<b>Client</b>	Hawthorn
<b>Project</b>	Portland, ME
<b>Lead Designer</b>	
<b>Production Manager</b>	Jason DiOrazio
<b>Production Staff</b>

2 SECOND FLOOR - CEILING
 SCALE: 1/16" = 1'-0"

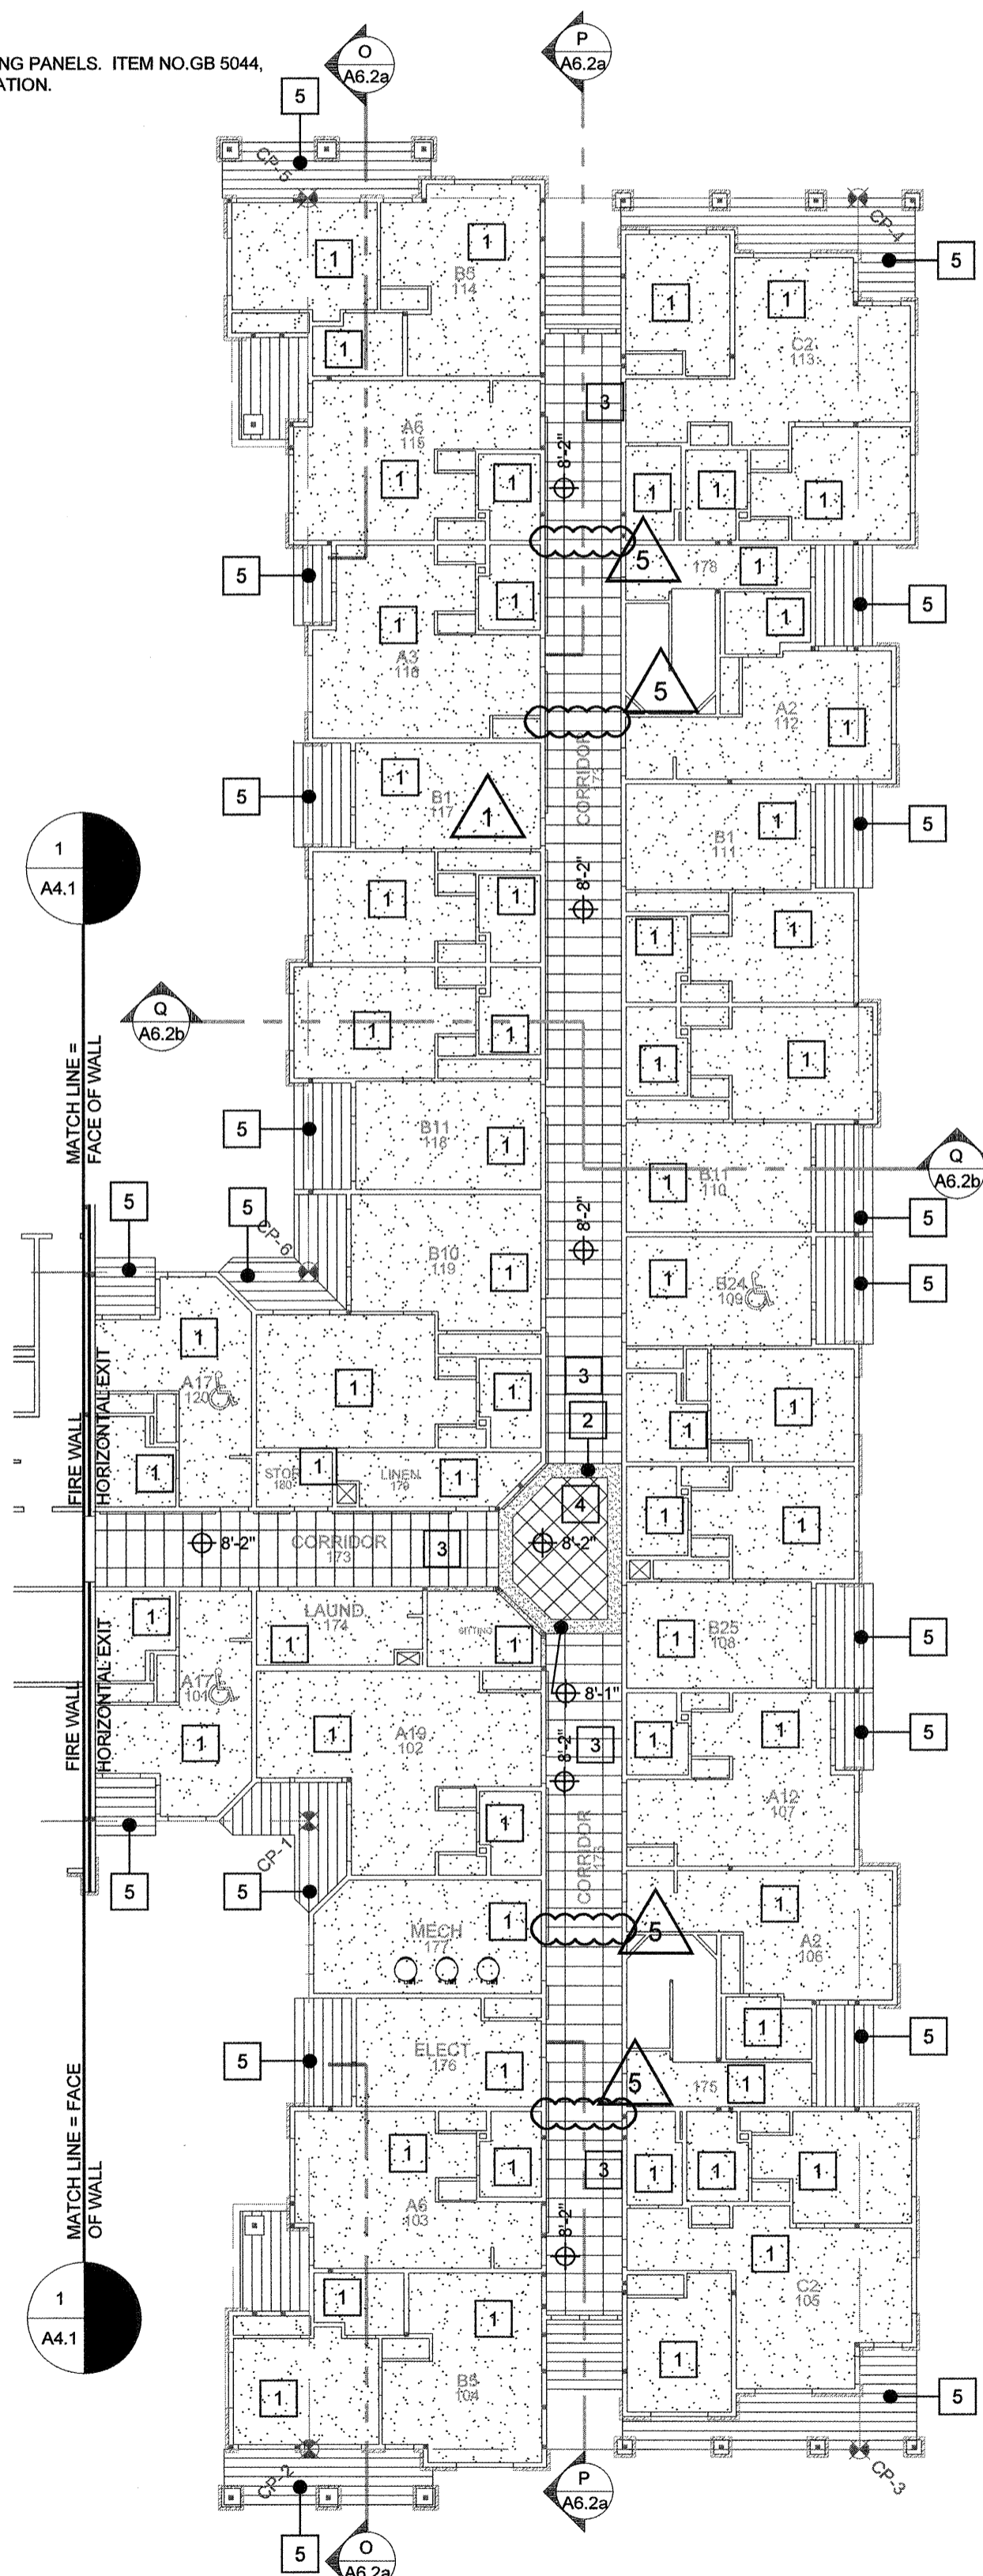
5	A4.3	Soffit removed in corridor, added soffits in B7 unit 339	Y			8/26/2016
5	A4.4	Soffit removed in corridor	Y			8/26/2016
5	A4.5	Soffits removed in corridor - all floors	Y			8/26/2016
5	A4.6	Soffits revised at corridor "turn" at floors 1-3, soffits removed in corridor all floors	Y			8/26/2016
5	A4.7	Soffits in Private Dining revised	Y			8/26/2016
5	A5.1	Added key boxes at Office, louvered door added to Co-Manager unit, time rating/clarification added at all mechanical case callouts, louvered door added to Laundry room	Y			8/26/2016

SHEET
A8.8

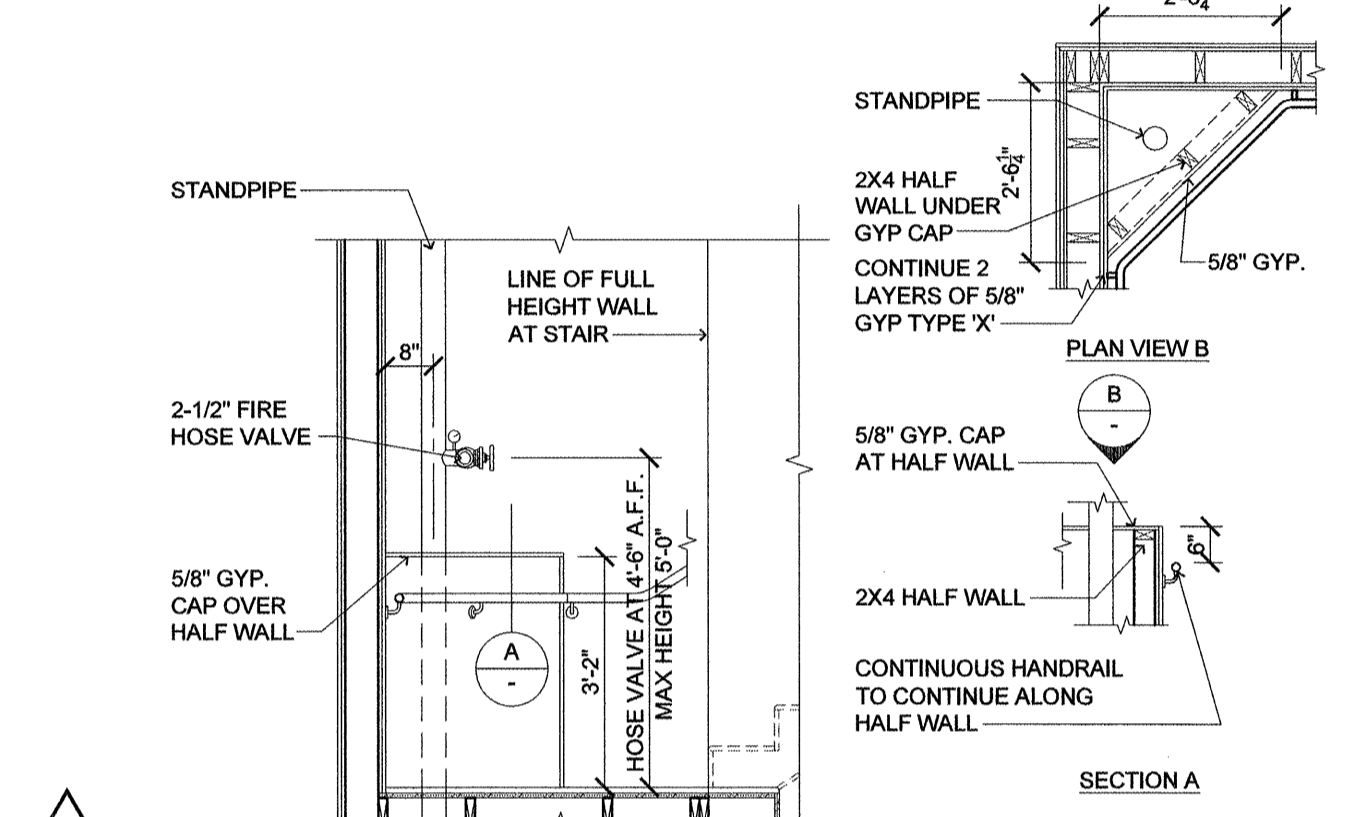
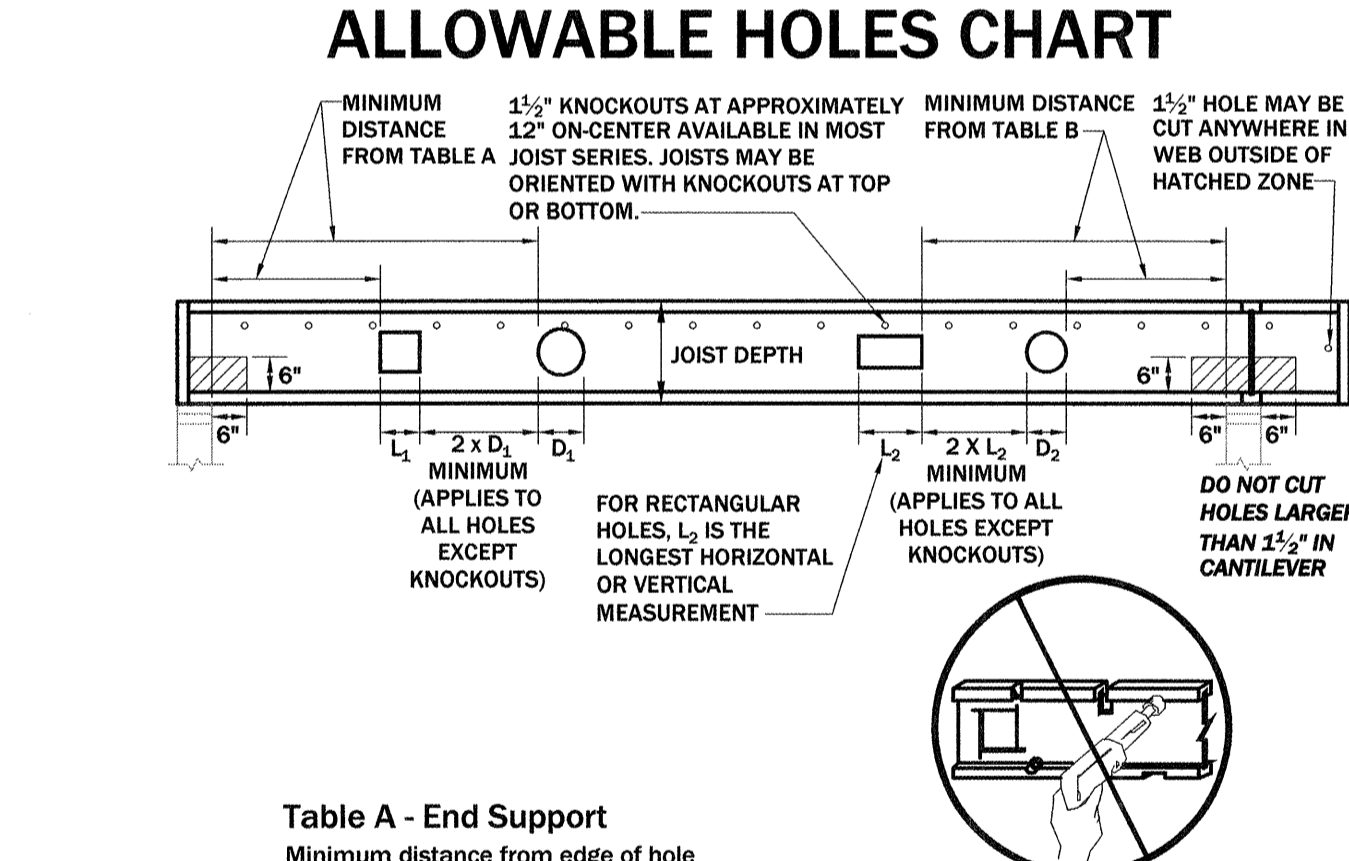
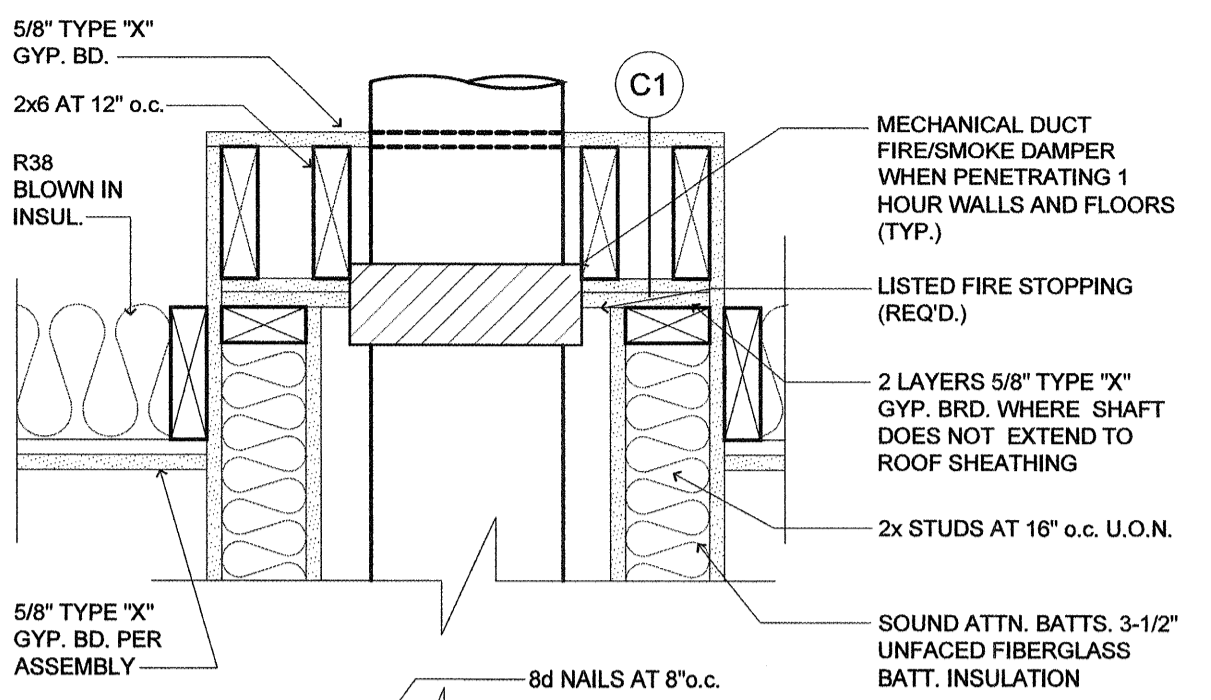
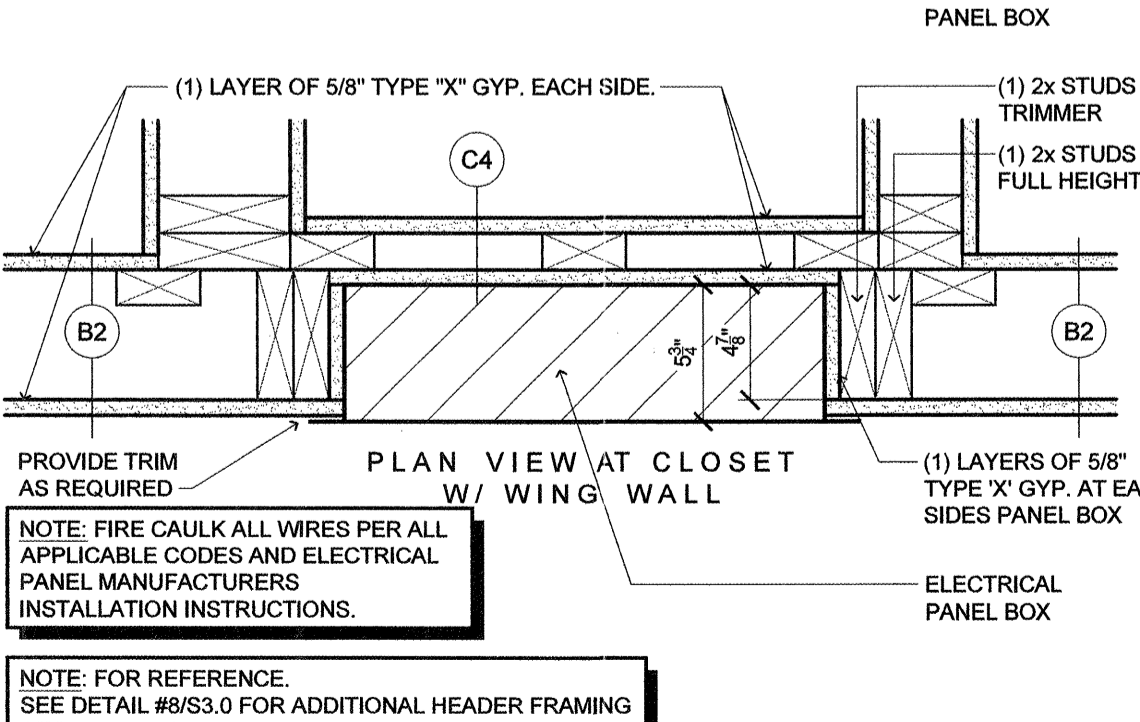
5	A8.6	Details 5 and 7 revised, detail 14 updated to be 2 hour detail, details 15-17 added to sheet	Y		8/26/2016
5	A8.7	Details 3 and 8 removed, details 2 and 6 revised	Y		8/26/2016
5	A8.8	Detail 8 revised to be 1 hour detail, details 9-11 added to sheet	Y		8/26/2016
5	A9.1	Sheet added to set	Y		8/26/2016
5	S0.1	Holddowns added at Office/Staff Room area	Y		8/26/2016
5	S0.2	Shearwalls revised at Office/Staff Room area	Y		8/26/2016
5	S1.1	Footing added at Marketing/Office area, foundation updated at Office/Staff area, patio revised between Staff and Private Dining	Y		8/26/2016
5	S1.2	Foundation added for new low roof near wing ends, new detail callout 3/S2.2 added	Y		8/26/2016
5	S1.3	Foundation added for new low roof near wing end, new detail callout 3/S2.2 added	Y		8/26/2016
